3rd August 2021

Application No: WA/63/21/PL
Site Address: Land East of Tye Lane Walberton BN18 0LU
Description of works: Proposed alternative vehicular accesses off Tye Lane and emergency access off Avisford Park Road, along with minor highway works following WA/95/18/RES (resubmission following WA/93/20/PL). This site is CIL Zone 2 (Zero Rated) as other development.

Drawing Title:
PROPOSED ALTERNATIVE ACCESS

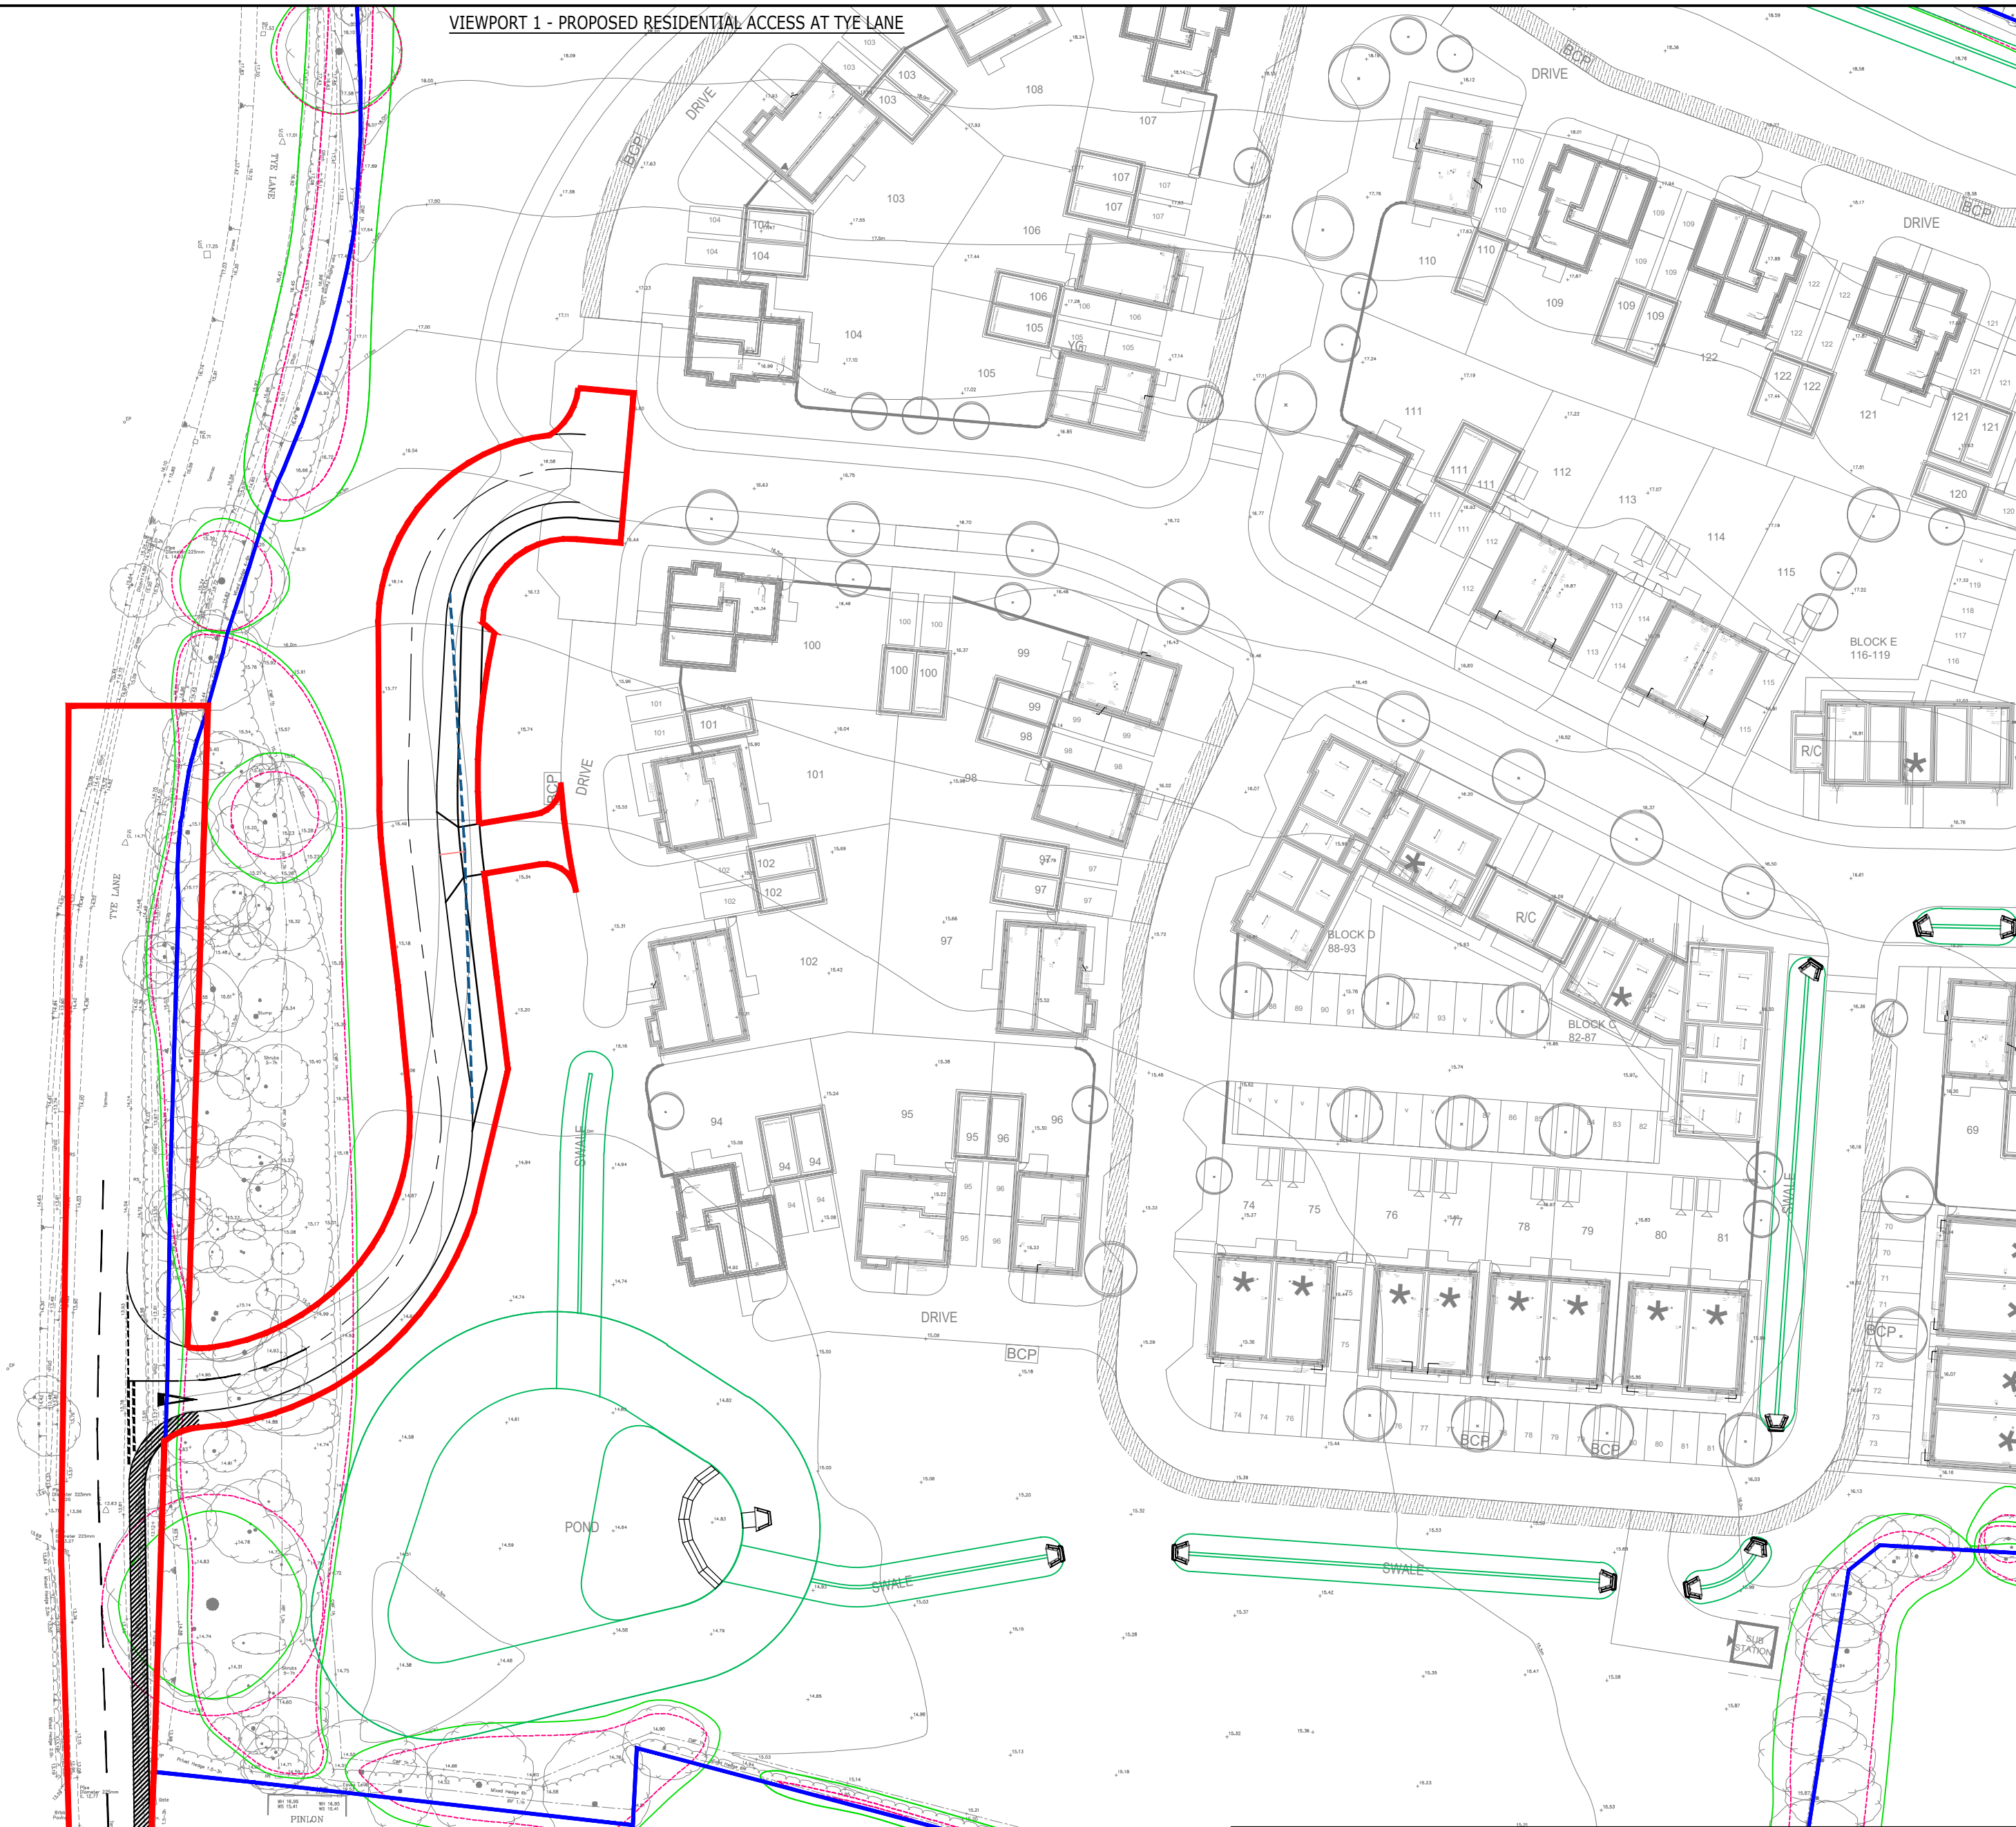
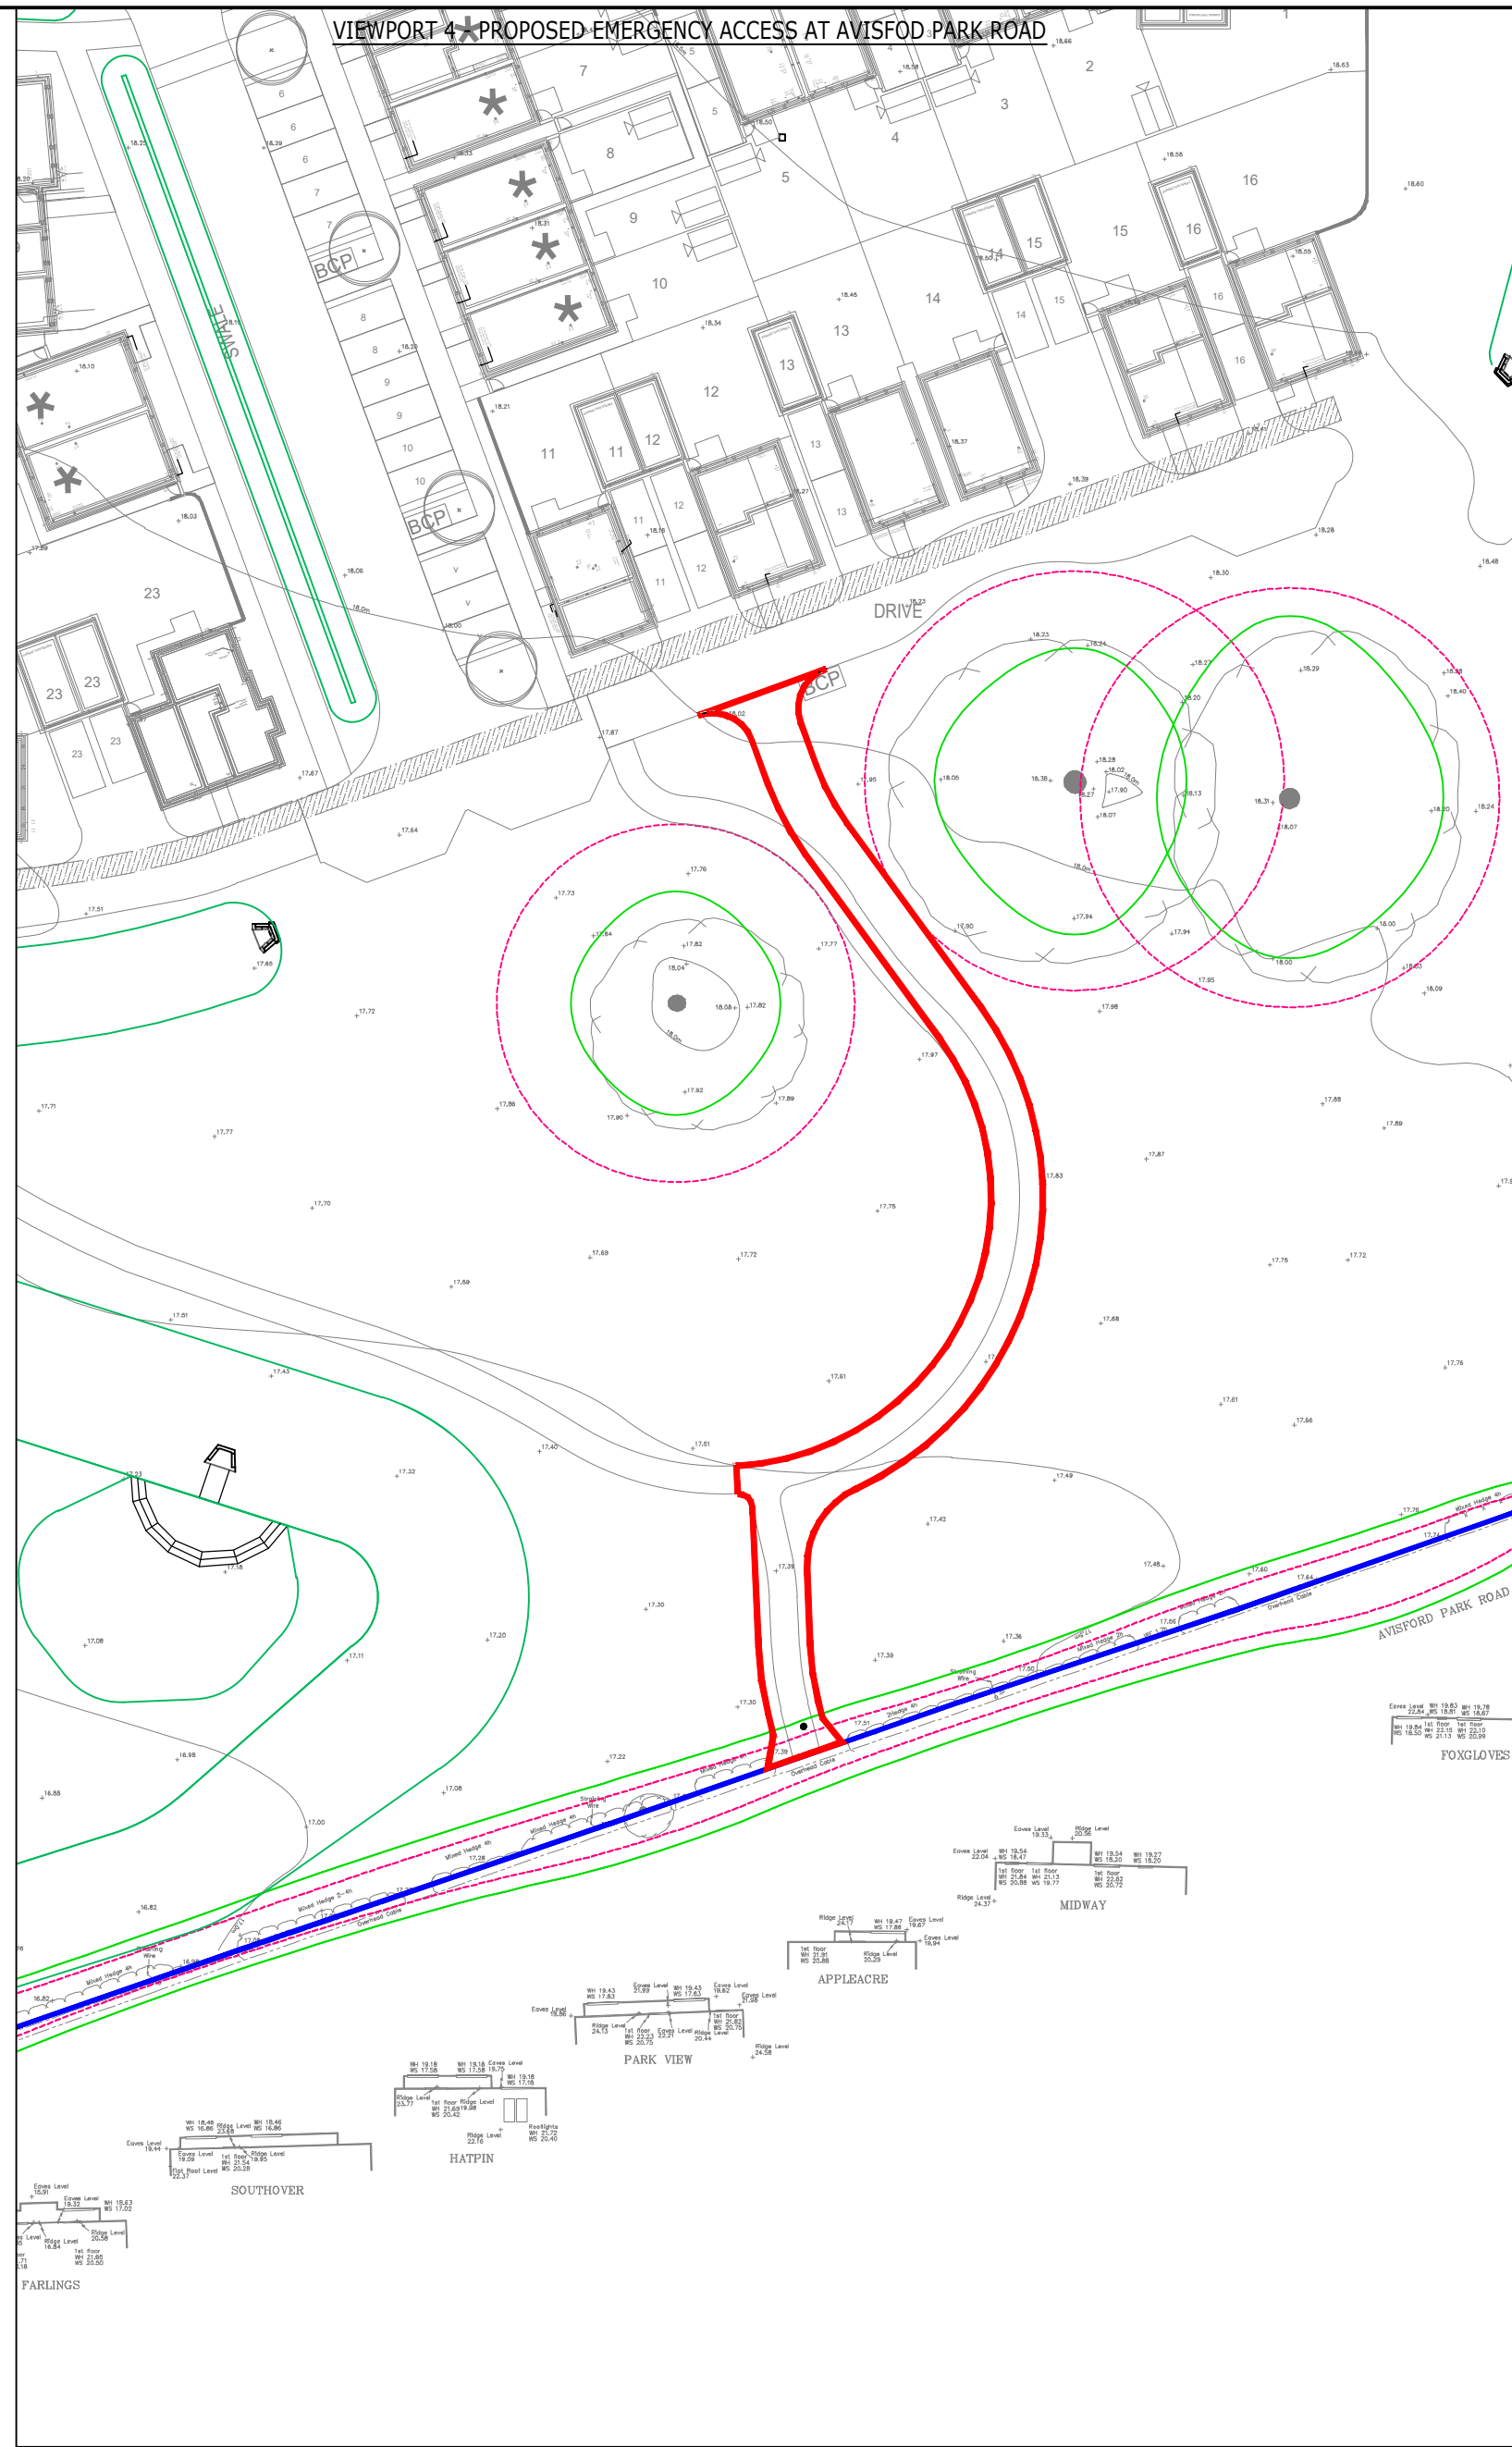
In Tye Lane two cars can just about pass each other with care and often with hedgerow growth scraping the side of the car, and they want to reduce the width of the carriageway! According to the document Transport Assessment Addendum 183248-07 (dated 01-07-2021), it states that an HGV and car require 4.8 metres to pass. My car is 2.13 metres wide (wing mirror to wing mirror). A Ford Transit van is 2.72 metres wide. So, with a road width of 4.8 metres, this leaves 40cms to accommodate the clearance between the vehicles and between the vehicles and hedgerows. Even with the 5 metres that are proposed that only leaves 60cms and we're not even talking HGV here.
